Appendix C – Detailed Response to Submissions

Item	Issue Raised	Comment
Department of Planning, Housing and Infrastructure (DPHI)		
Wran Building Materiality		
DPHI1	Provide a clear rationale for the extent of demolition proposed to the Wran building, including any analysis undertaken that considered alternative approaches.	<ul style="list-style-type: none"> The Wran building and adjacent Galleria have been extensively modified since first opening of the museum in 1988. Originally designed as the front door and shop, the Wran Building now houses exhibition spaces following works in 2011-2013, with the museum entrance on the southern façade. The resulting exhibition space does not provide the internal environment suitable for modern museum practice with insufficient light and acoustic separation and intrusion from internal columns and mezzanine offices. The recladding of the Wran façade will improve the environmental and amenity performance of the exhibition space, by particular, improving acoustic and light control. The removal of columns and mezzanines (that are no longer required for office space) will further create the necessary flexible flat floor exhibition space that the mu

drawing	SECTION E																												
drawing no.	A.DA3004	issue Rev G

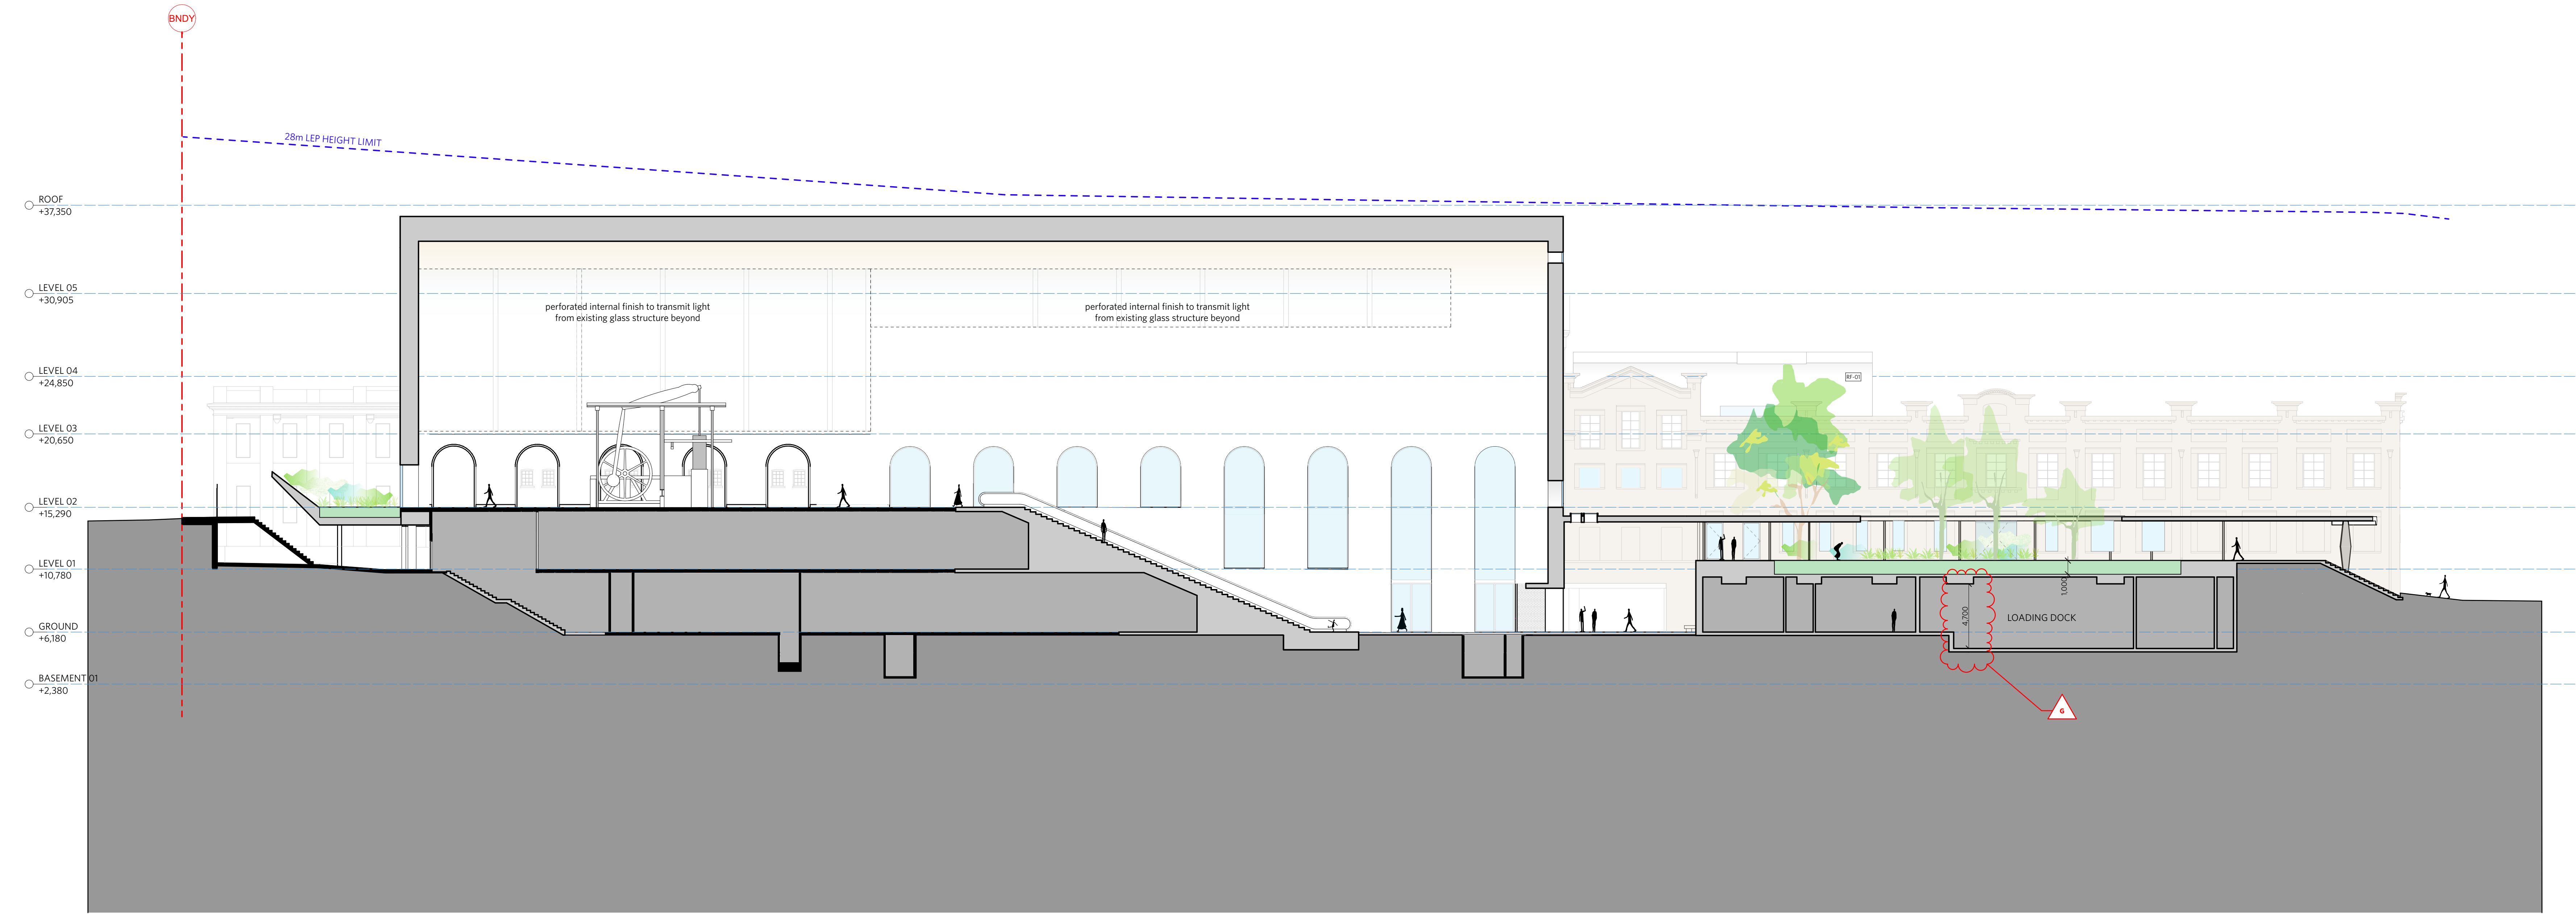
DPHI1	<ul style="list-style-type: none"> In response to the concerns raised by Council, confirm whether hook lift bins can be collected within the proposed architectural scheme or provide details of an alternative waste collection approach. 	The amended architectural plans provided at Appendix F (A.DA3004-SECTION E) demonstrates that there is at least 4.7m height clearance within the loading dock. No alternative collection approach is required.
Landscaping and Public Domain		
DPHI2	Explore opportunities to retain Trees 3 and 4 as requested by Council.	<p>As outlined in the Amended Public Domain Statement (Appendix Q to the Submissions and Amendment Report dated 3 September) the location of the proposed building will impact upon the tree protection zones of these trees. Following the recommendation of the project arborist, these trees are proposed for removal.</p> <p>Whilst there is limited capacity to move the building, the Proponent is willing to investigate the ability to retain these trees. The Proponent is willing to accept a condition of consent to further investigate the ability to retain these trees in this location despite the impact of the building.</p> <p>It is noted that the proposal seeks to provide 26 new trees, including street trees and new trees in the newly appointed open spaces on the site.</p>

project	POWERHOUSE ULTIMO REVITALISATION 500 Harris Street Ultimo NSW 2007 Australia	
drawing	AREA PLANS EXISTING SHEET 02	
drawing no.	A.DA6004	issue Rev G

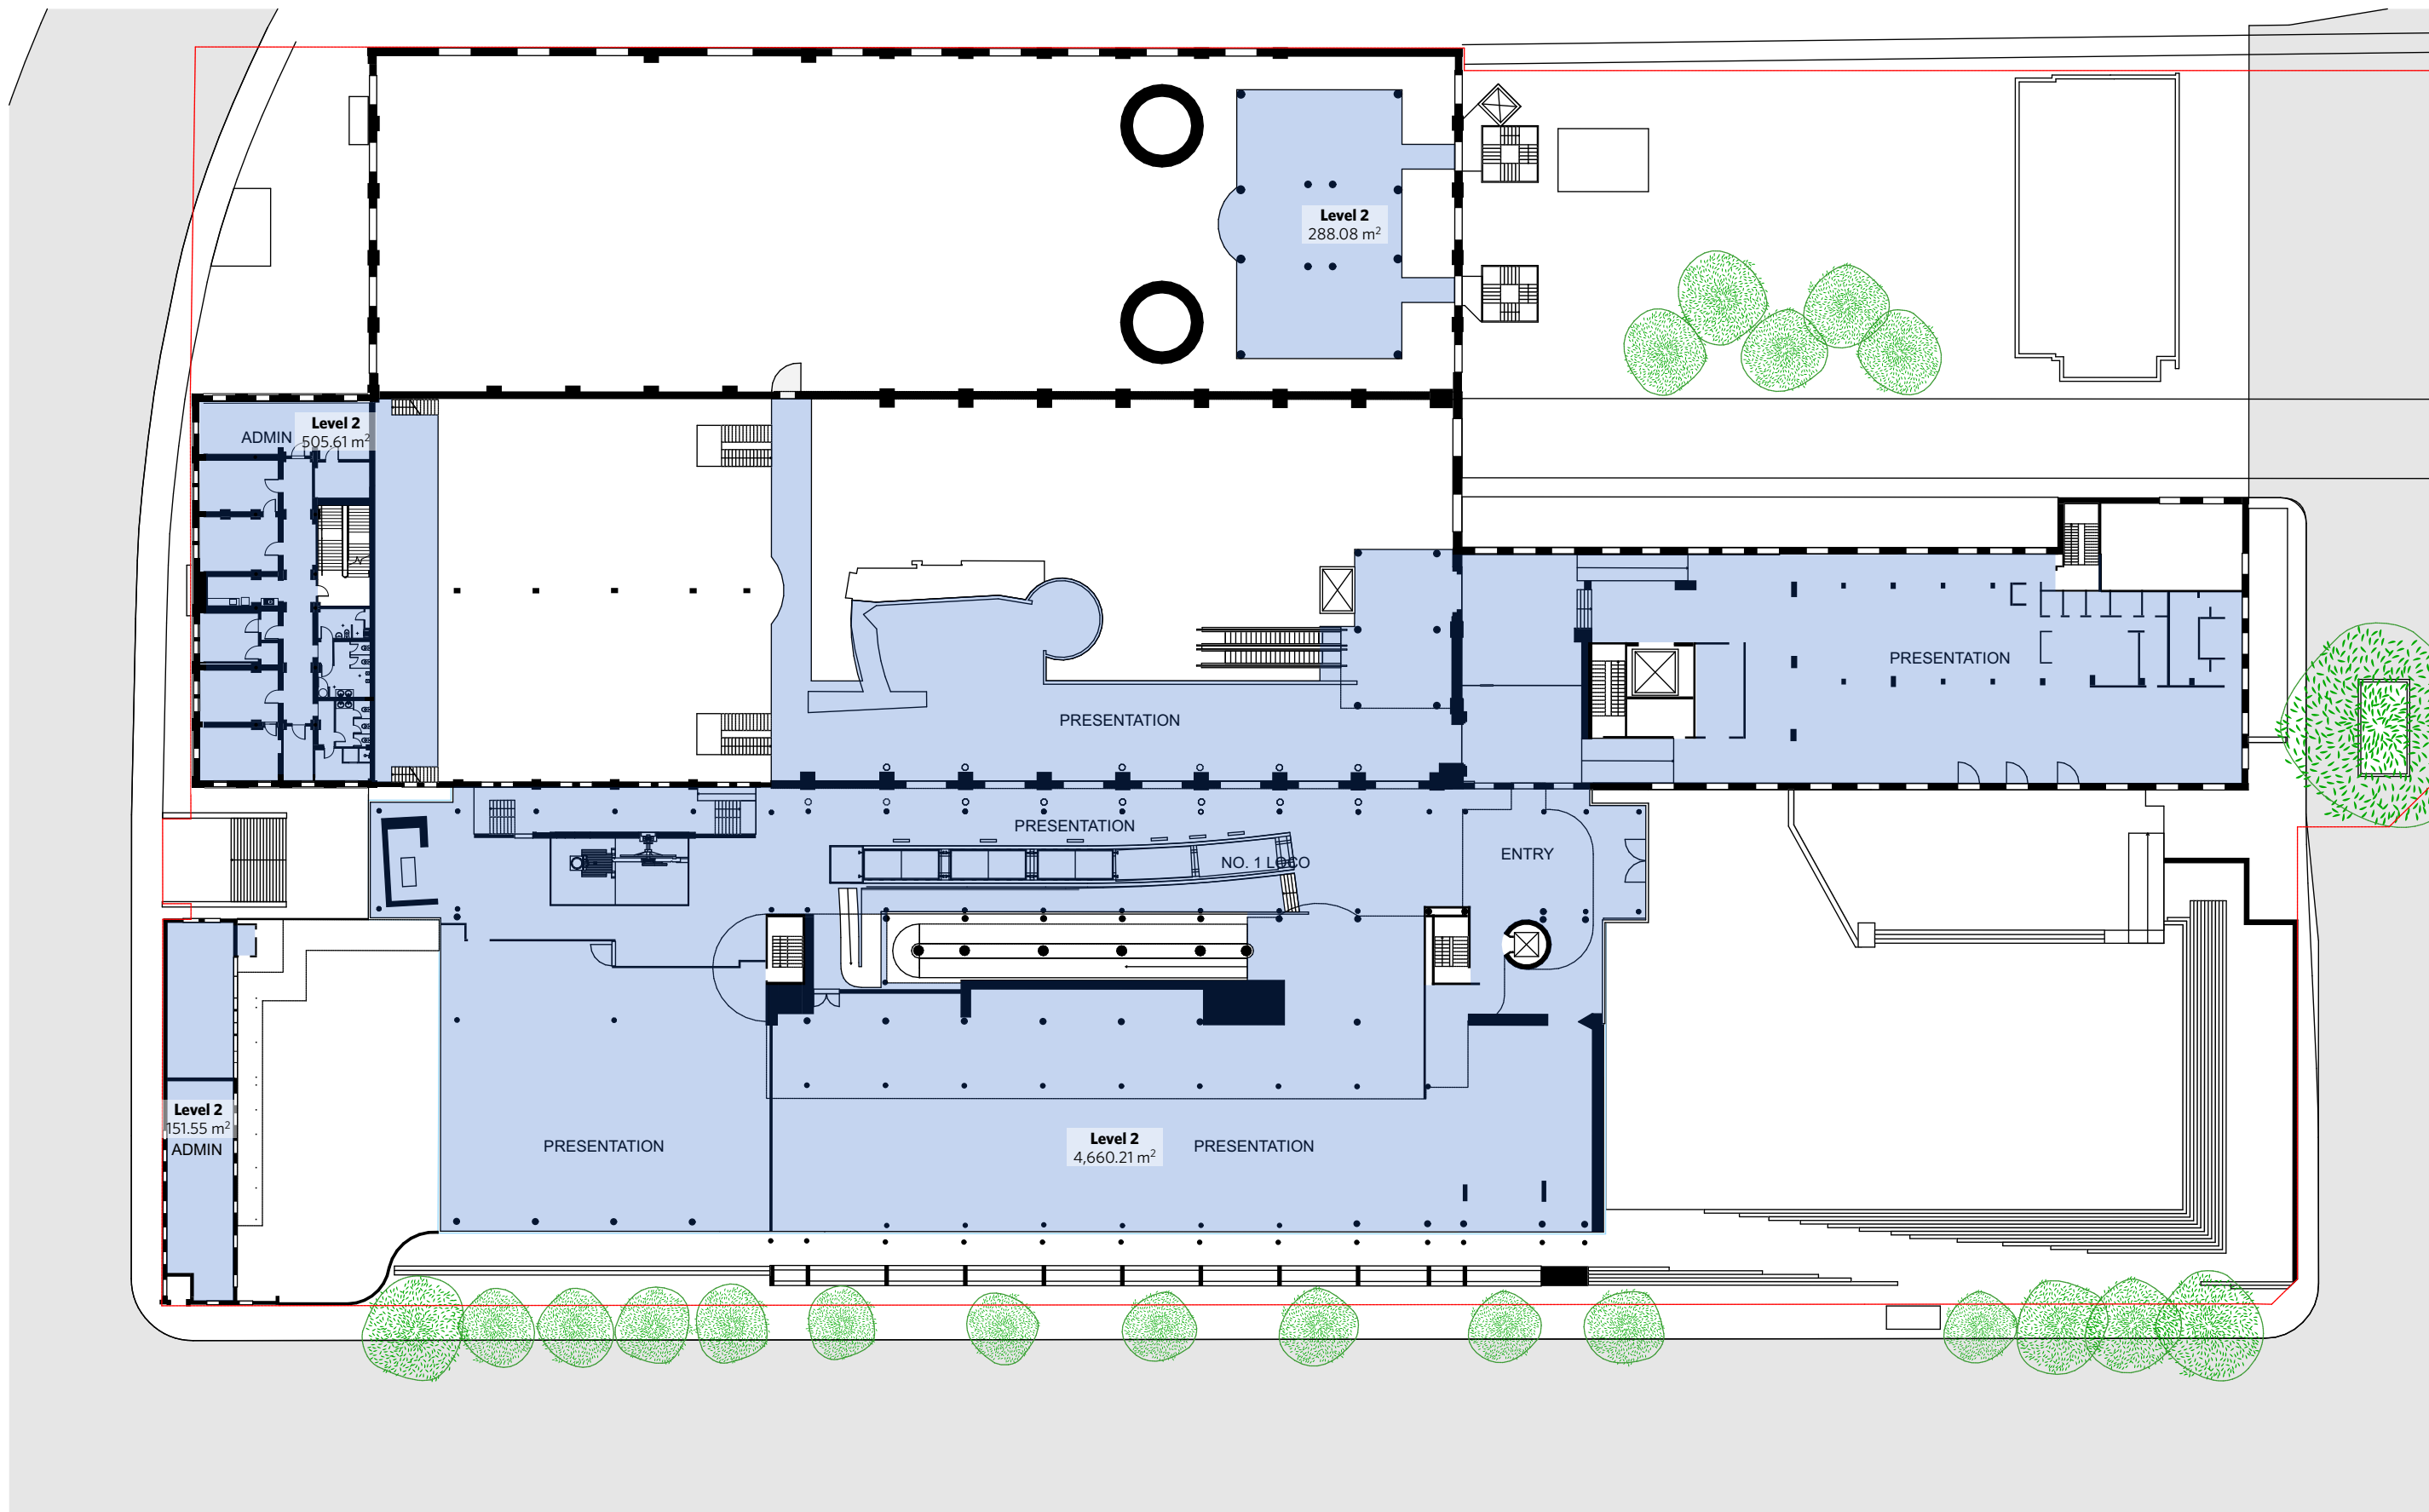
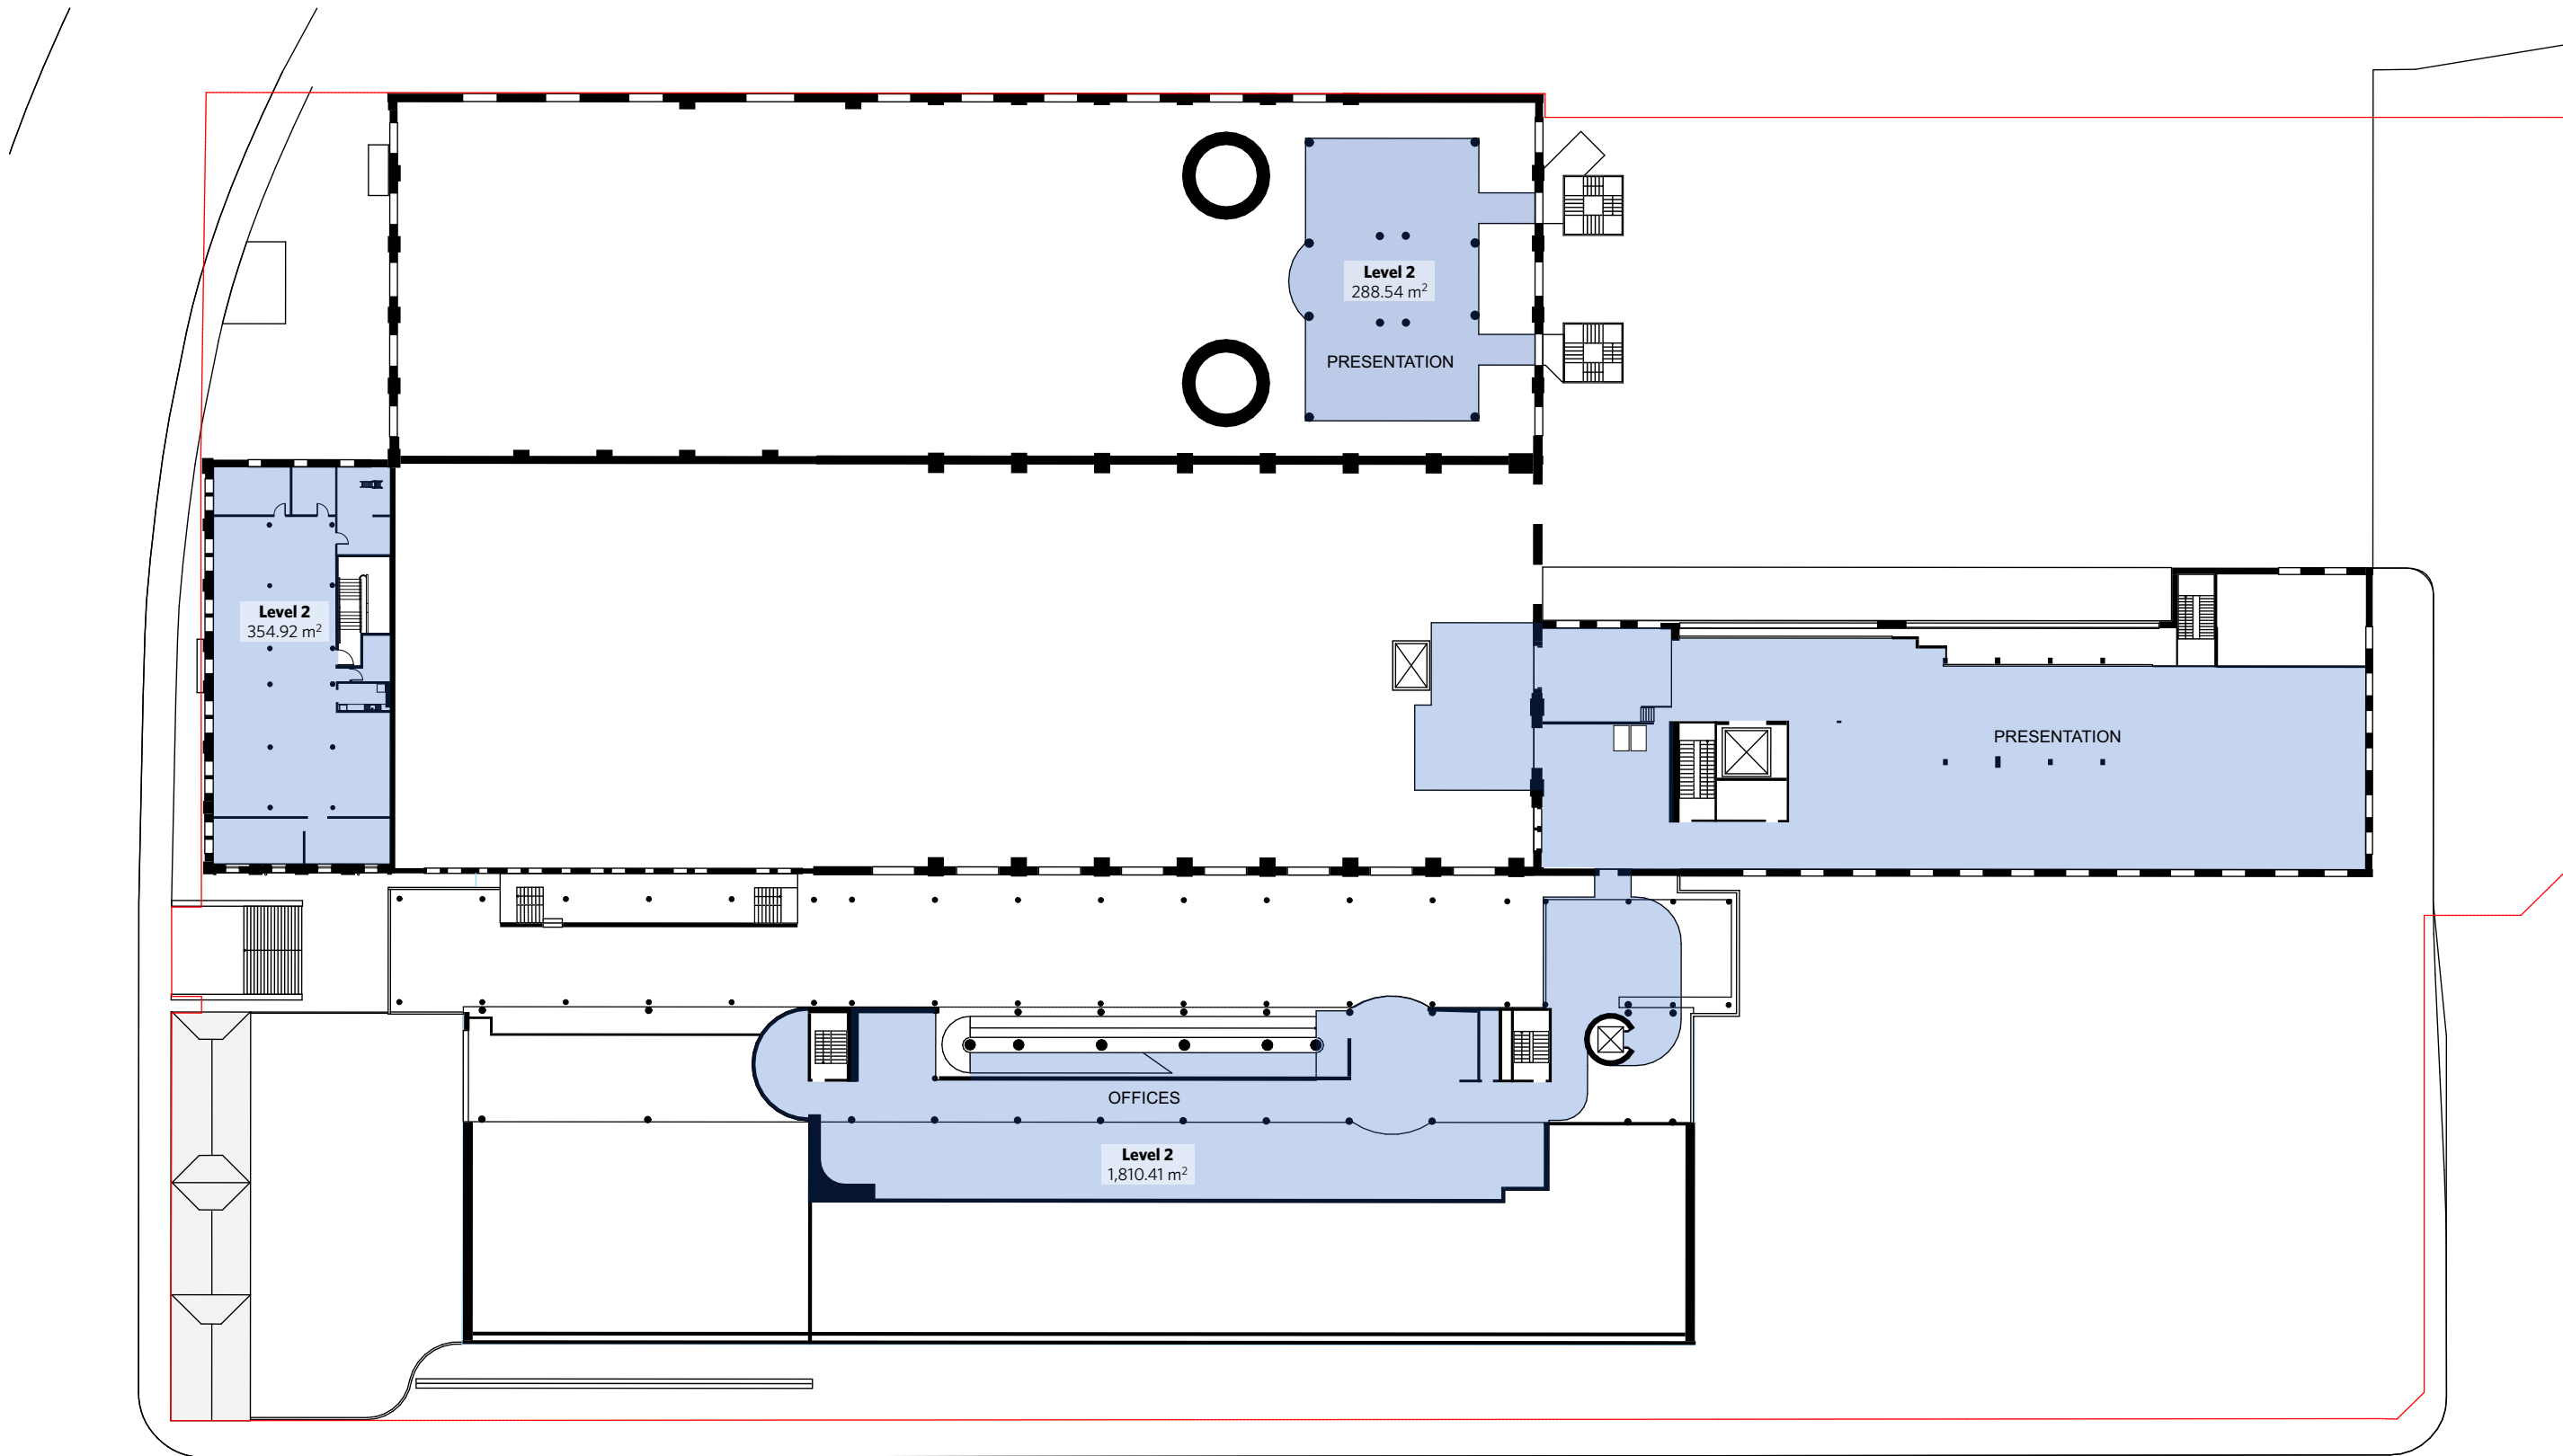
<p>dynamic programs that facilitate direct connections with Powerhouse collections are essential for the museum's future.</p> <p>The revitalisation of Powerhouse Ultimo is occurring within the context of the wider Powerhouse program that includes the recent expansion of Powerhouse Castle Hill) the establishment of Powerhouse Parramatta (under construction) – together these facilities represent a significant expansion of the Powerhouse's museum spaces and overall capacity to deliver programming with increased diversity, reach, and relevance to the community.</p>
CoS3	<p>The City notes a discrepancy between the existing gross floor area (GFA) plans submitted for the original design and the amended design, as well as an overall reduction of 873.15sqm in the amended proposal. Back of house at ground floor appears to be excluded, which is inconsistent with the definition of GFA contained in the Sydney Local Environmental Plan 2012. This discrepancy should be resolved and publicly clarified prior to a determination. The following comments are made in response to the amendments proposed and are provided for your consideration.</p>	<p>DBJ has provided updated GFA plans at Appendix E to provide clarification on the existing compared to the proposed GFA as well as the back of house floor area (refer to A.DA6000).</p> <p>The GFA plans have been updated to reflect a recalculation of GFA in alignment with the GFA definition under the Sydney LEP. These plans have clarified areas where the use was previously ambiguous, and it was unclear whether these spaces would be consistent with the GFA definition (such as back of house versus plant room). The purpose of the plans is to clarify the use of these spaces and demonstrate how the GFA has been calculated.</p>

DPHI3	Consider opportunities for additional canopy tree planting in the Gathering Terrace to further improve tree canopy cover across the site.	The Gathering Terrace serves as the primary access point for transport of very large objects directly into the Turbine Hall. The proposed tree planting in the Gathering Terrace maximises the available area for tree planting without inhibiting the ability to load and unload objects into the museum spaces. For this reason, additional canopy tree planting is not able to be accommodated in the Gathering Terrace.
Other		
DPHI4	Clarify the proposed gross floor area (GFA) in accordance with the definition of GFA specified in the City of Sydney Local Environmental Plan 2012.	<p>DBJ has provided detailed GFA plans at Appendix E. The plans provide detailed area plan calculations in accordance with the definition of GFA as specified in the City of Sydney LEP 2012. Existing GFA plans are provided as well as the proposed GFA plans.</p> <p>In summary, the existing GFA of the Powerhouse is 23,002.31m² and the proposed GFA is 51, 257.99m².</p>
